KU-RING-GAI COUNCIL SUBMISSION
October 2010

SYDNEY ADVENTIST HOSPITAL (SAN)
WAHROONGA

Environmental Assessment
Staged Alterations and Additions
Application MP 10_0070

3 EDUC/01 EDUCATION CENTER SECTION
1:200 SCALE
SCALE 1:200

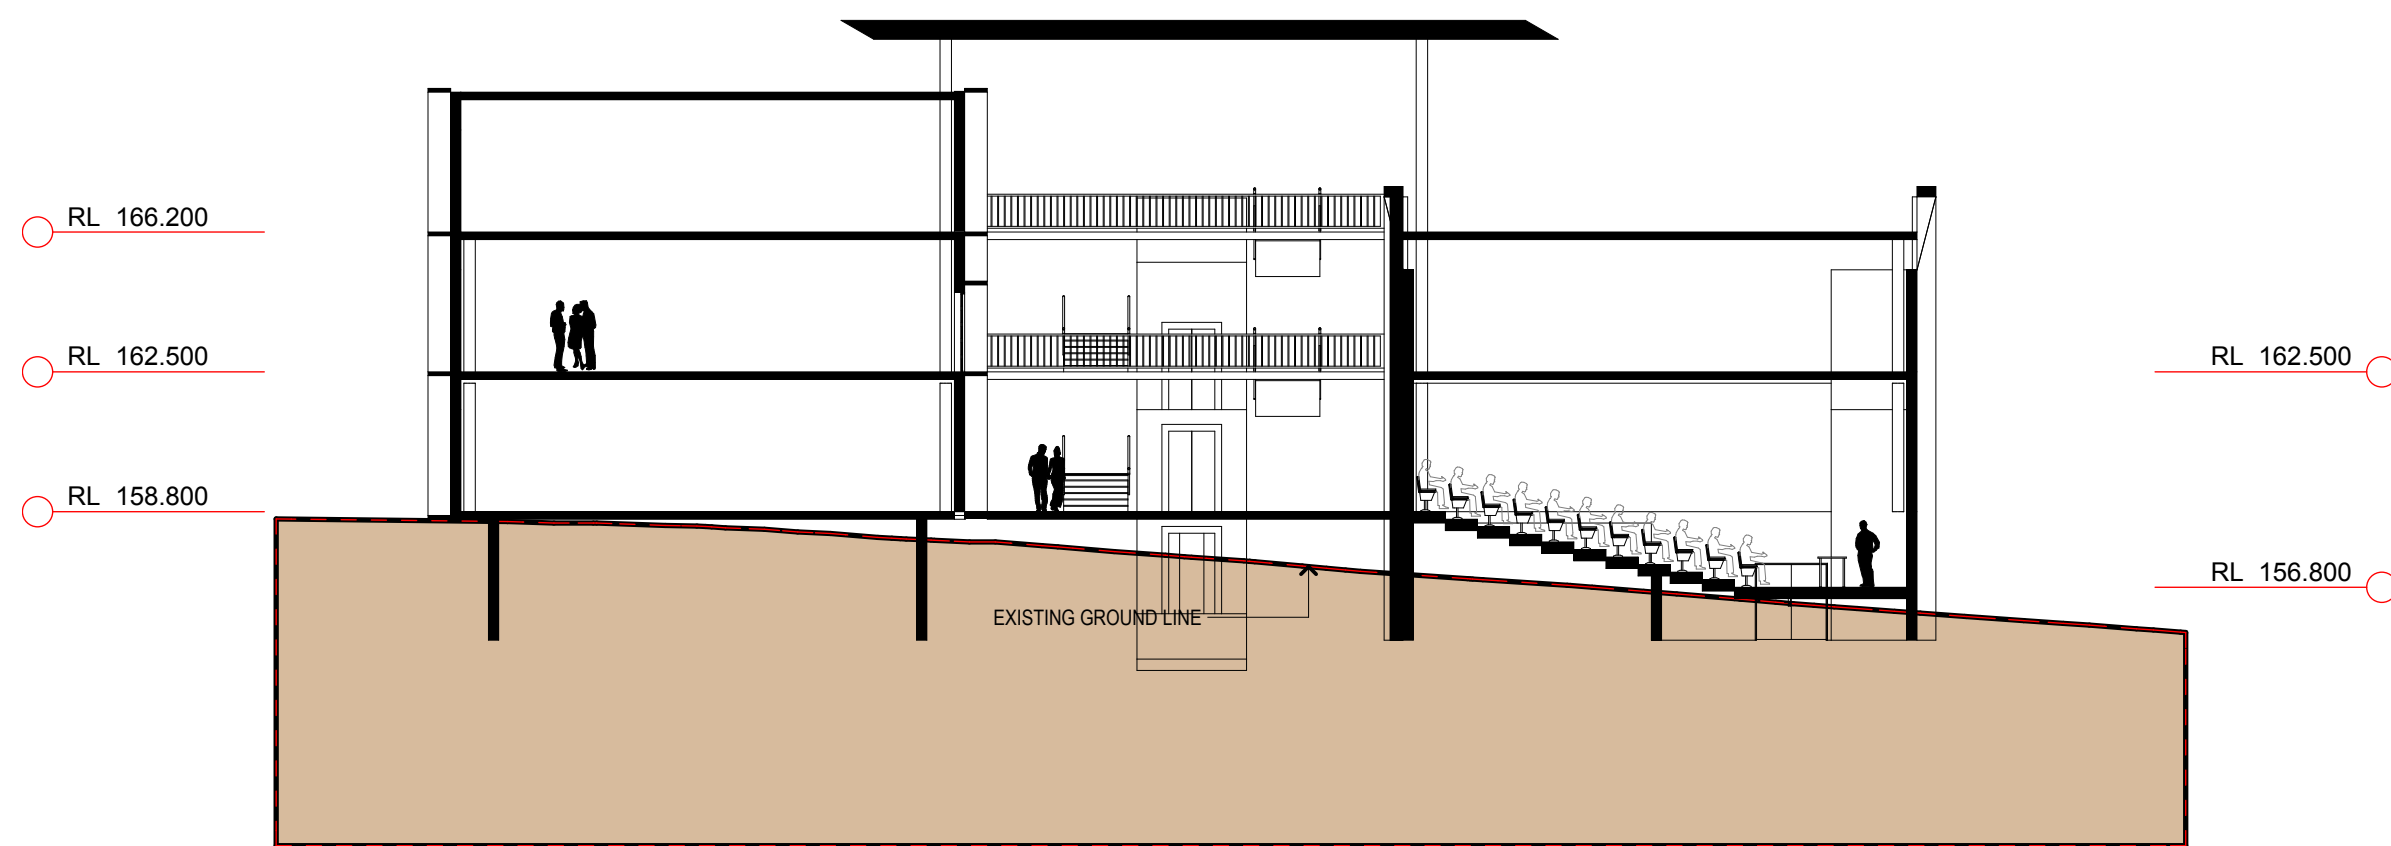
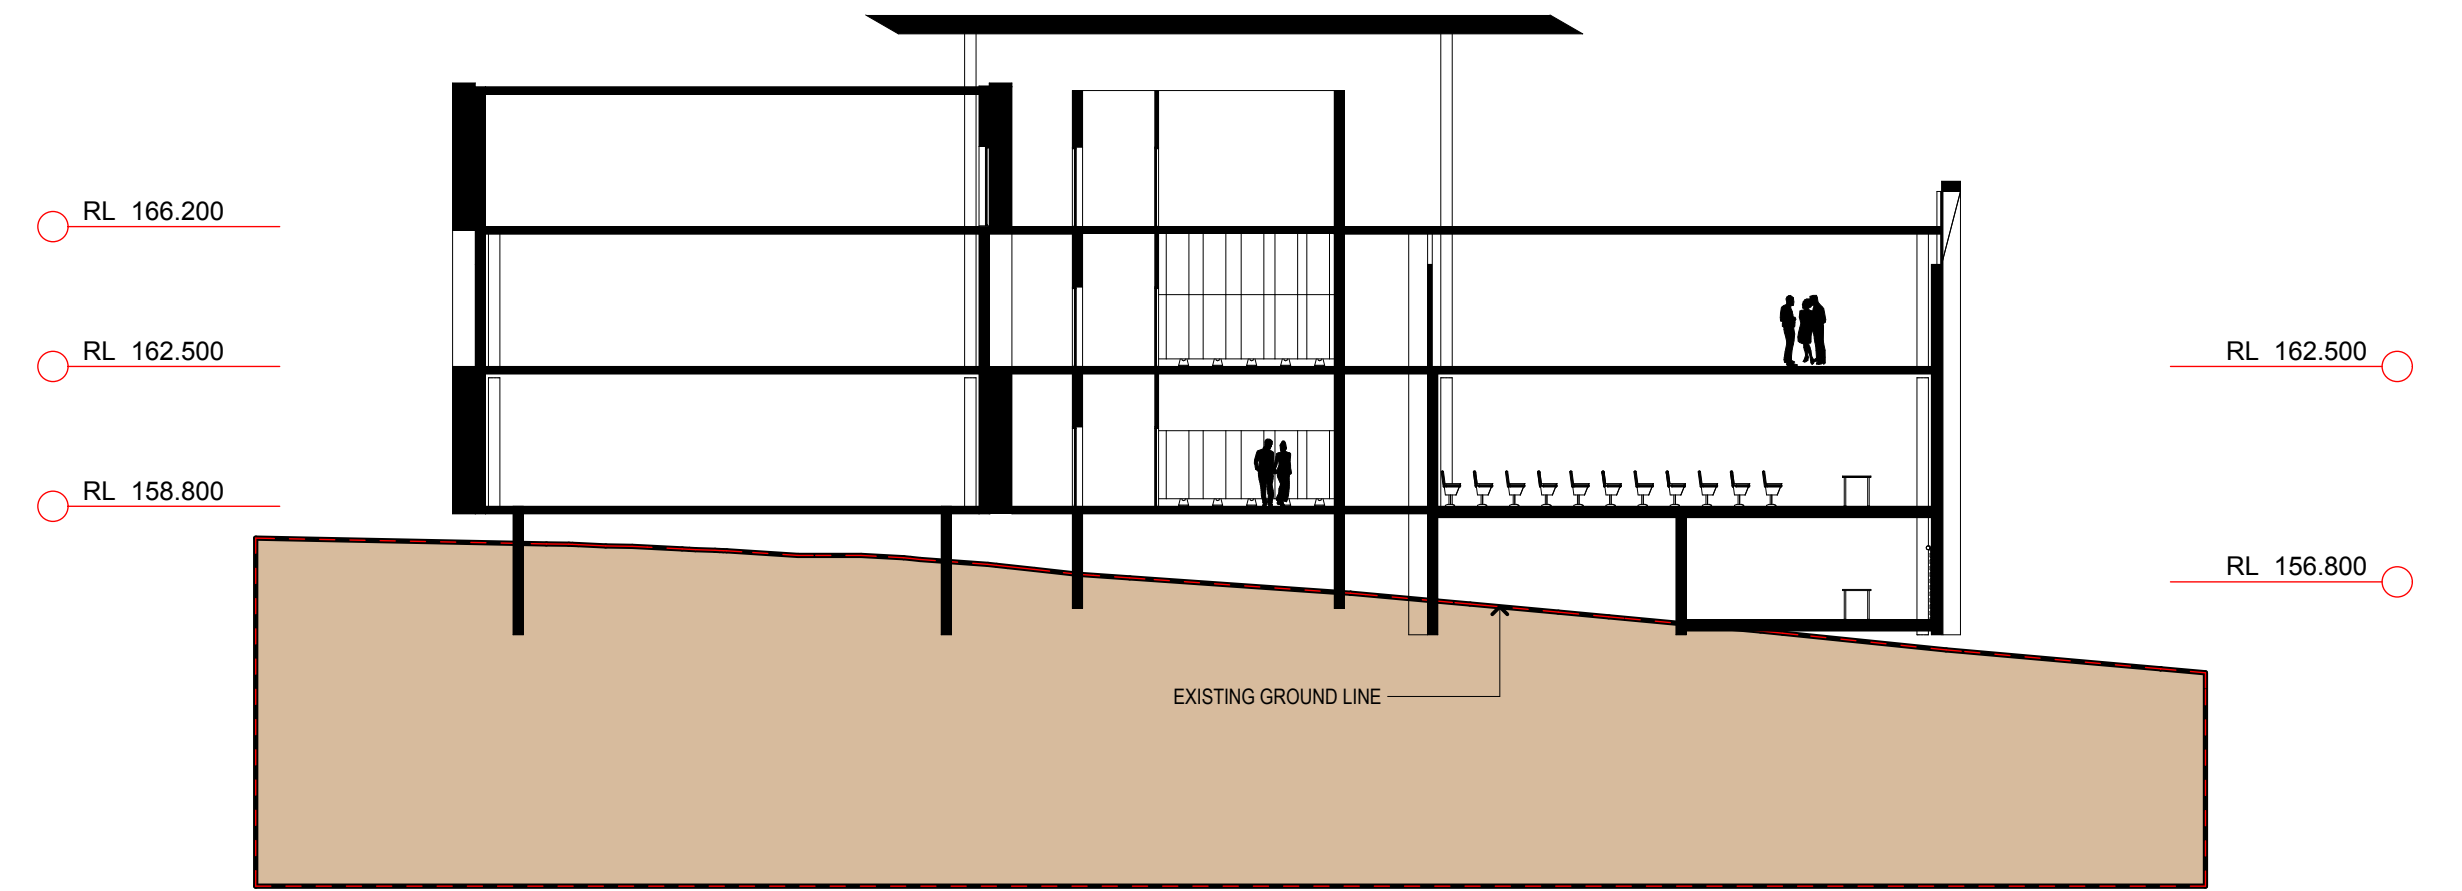
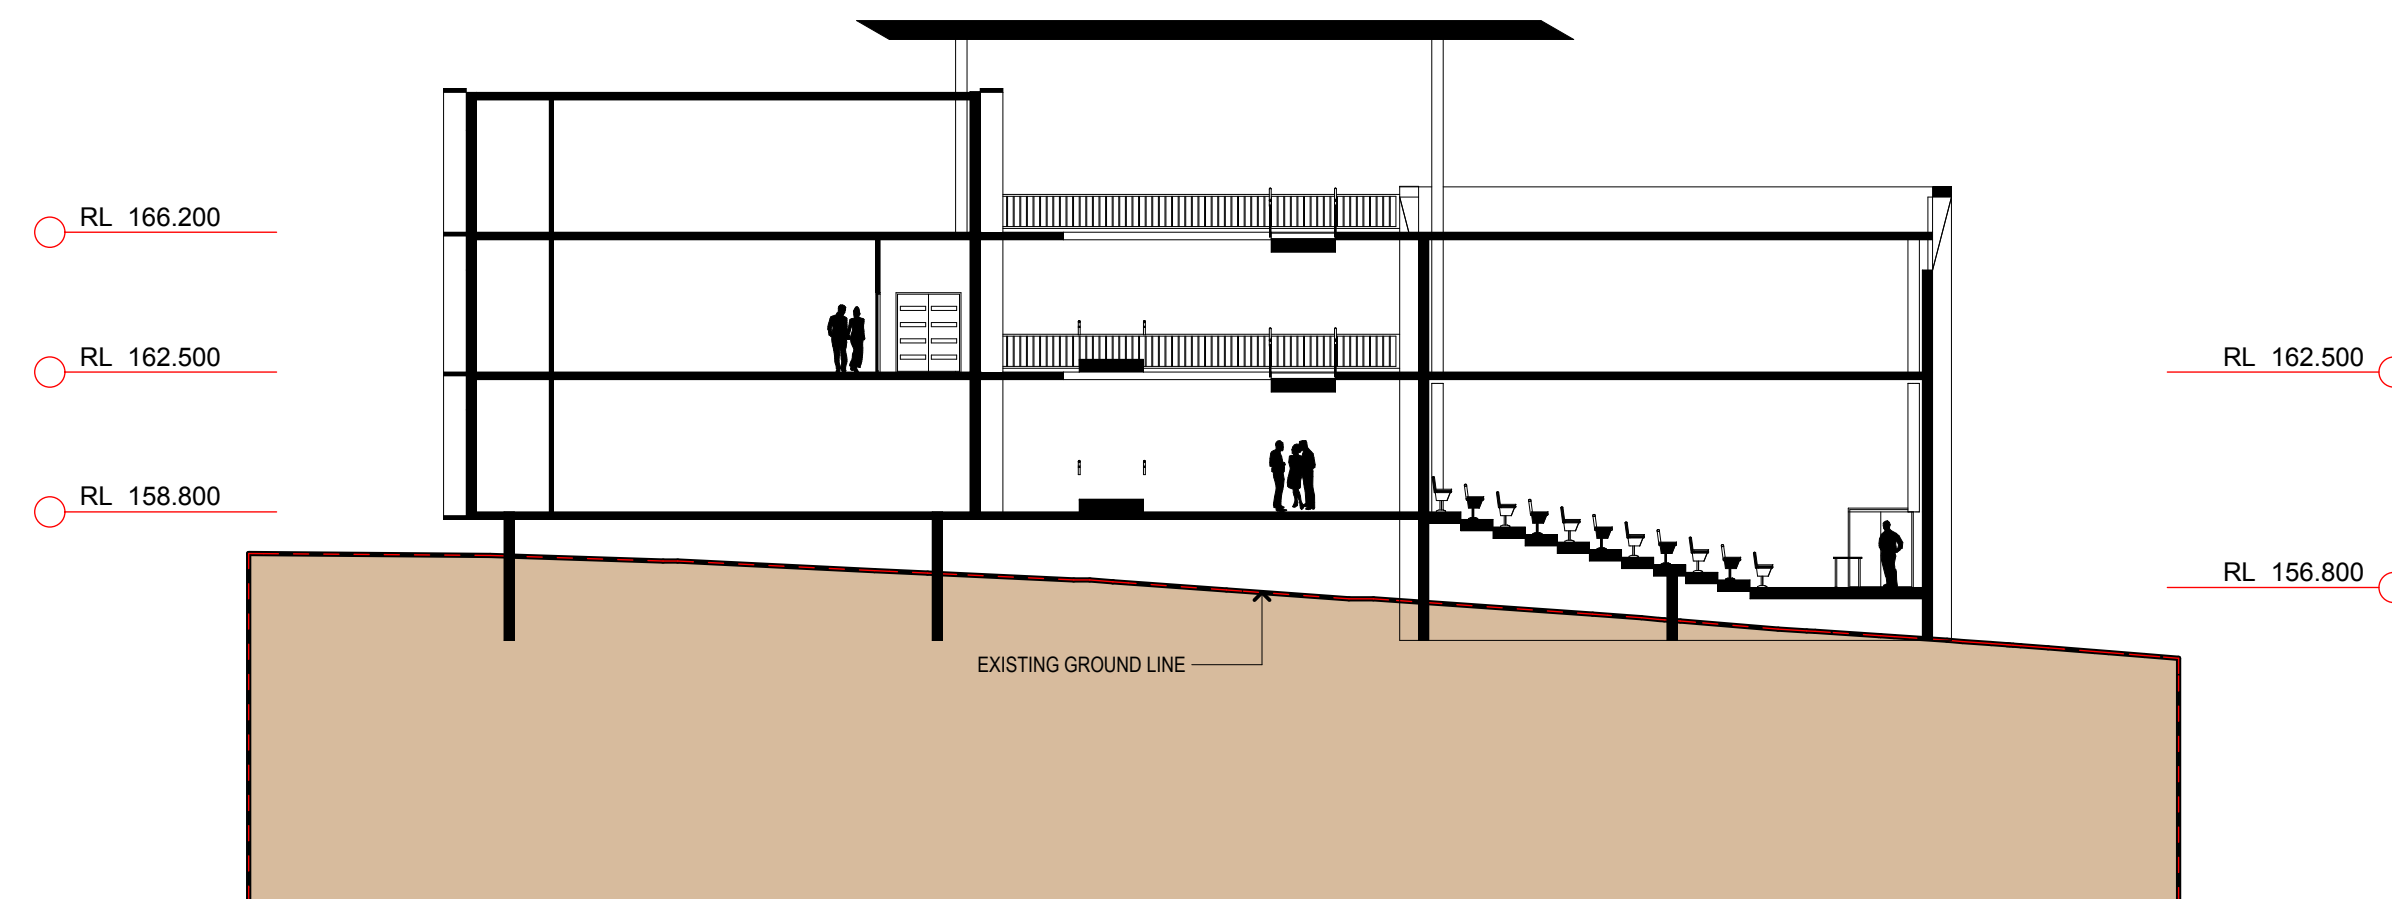
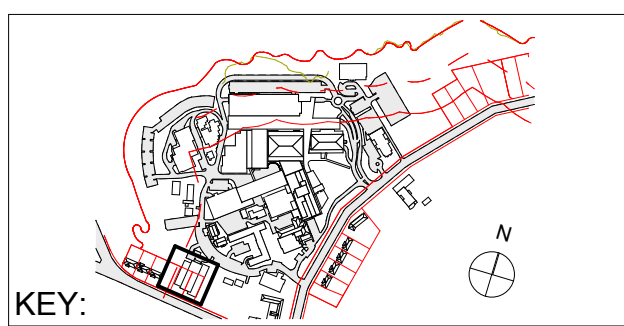
The maximum building height of the education centre does not appear to comply with the maximum 14.5m height allowed under the SEPP. It appears to be more than 15m high, based on the sections. However, the drawings lack the detail required to accurately assess the height. For instance the sections do not include any RLs, and are not all to the stated scale. Council cannot confirm that the new Shannon building and the CSB expansion comply with the height standard.
